Our Ref: LM/ARU/21/03B

Date 14th September 2021

RE: Land at Bilsham Road Yapton

Thank you for your correspondence of the 10th of September 2021, advising me of a planning application for Approval of reserved matters (appearance, landscaping, layout and scale) following the grant of Y/91/17/OUT for 250 No dwellings with associated parking, road/footway/cycleway provision, open space, landscaping, surface water attenuation & ancillary works (resubmission following Y/152/20/RES). this site is not CIL Liable as in Yapton Strategic Site at the above location, for which you seek advice from a crime prevention viewpoint.

PROJECT:	Bilsham Road Development LLP	Land at Bilsham Road, Yapton
SCALE:	1:100 (A1 ORIGINAL)	DRAWING: Apartment Blocks C, D, E, F 1BF - Elevations - Drove
DRAWN: RDB	19284	P216
DATE: July 2021		—

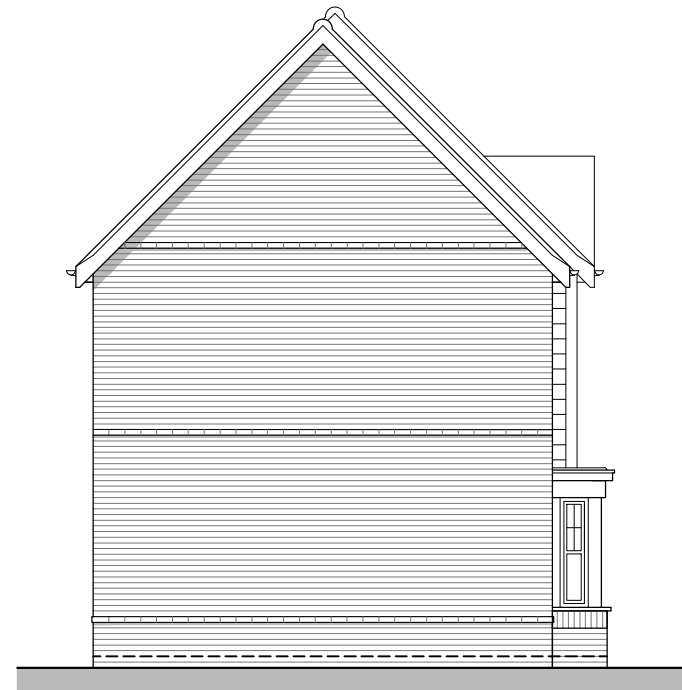
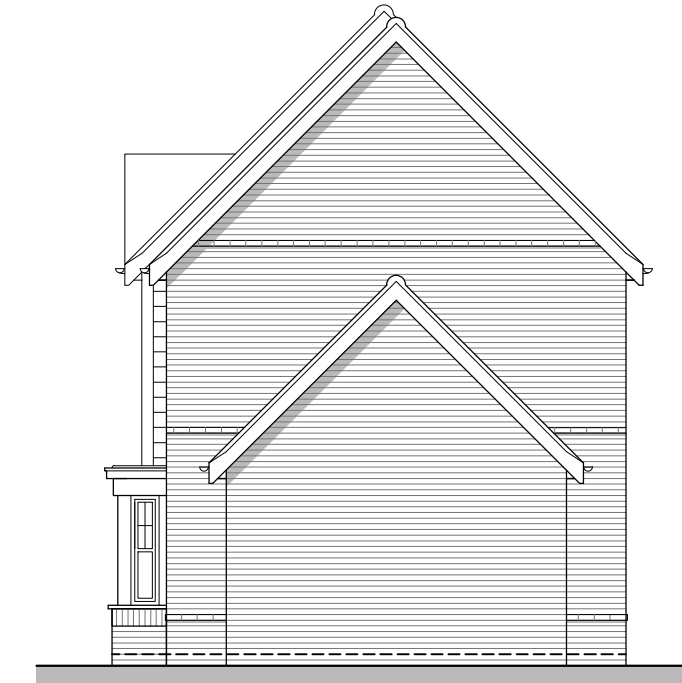
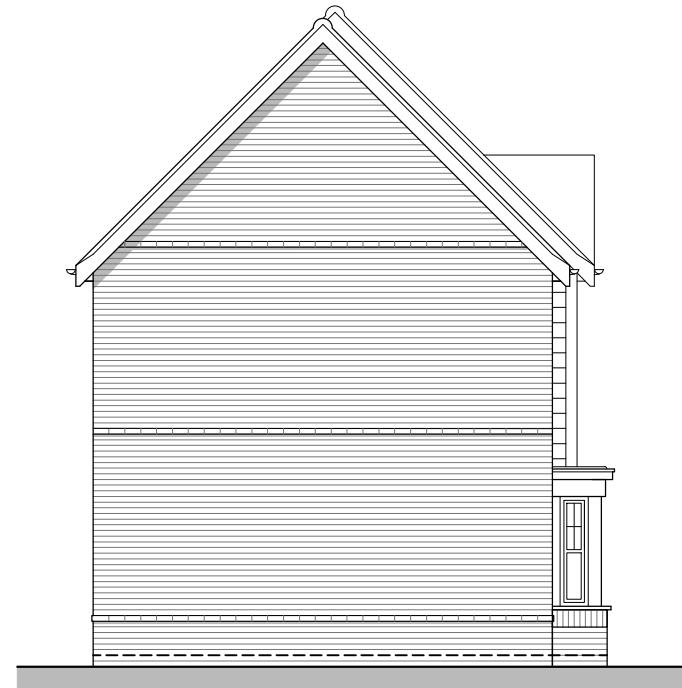
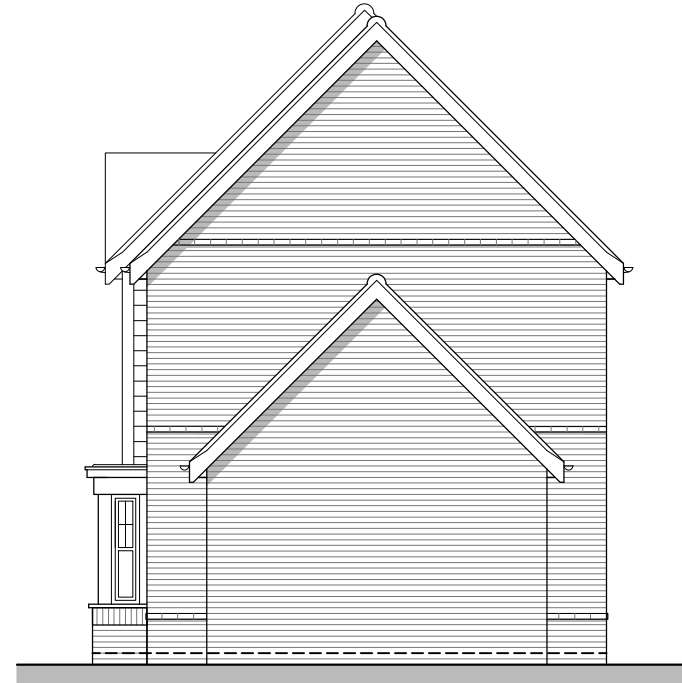
With regards to the apartment blocks - it will be imperative that access control is implemented into the design and layout to ensure control of entry is for authorised persons only. For additional information I refer the applicant to chapter 27 SBD Homes Version 2 2019.

Additionally, I recommend the postal arrangements for the apartments is through the wall or externally mounted secure post boxes. I strongly urge the applicant not to consider letter apertures within the apartment front doors. The absence of the letter aperture removes the opportunity for lock manipulation, fishing and arson attack and has the potential to reduce unnecessary access to the block.
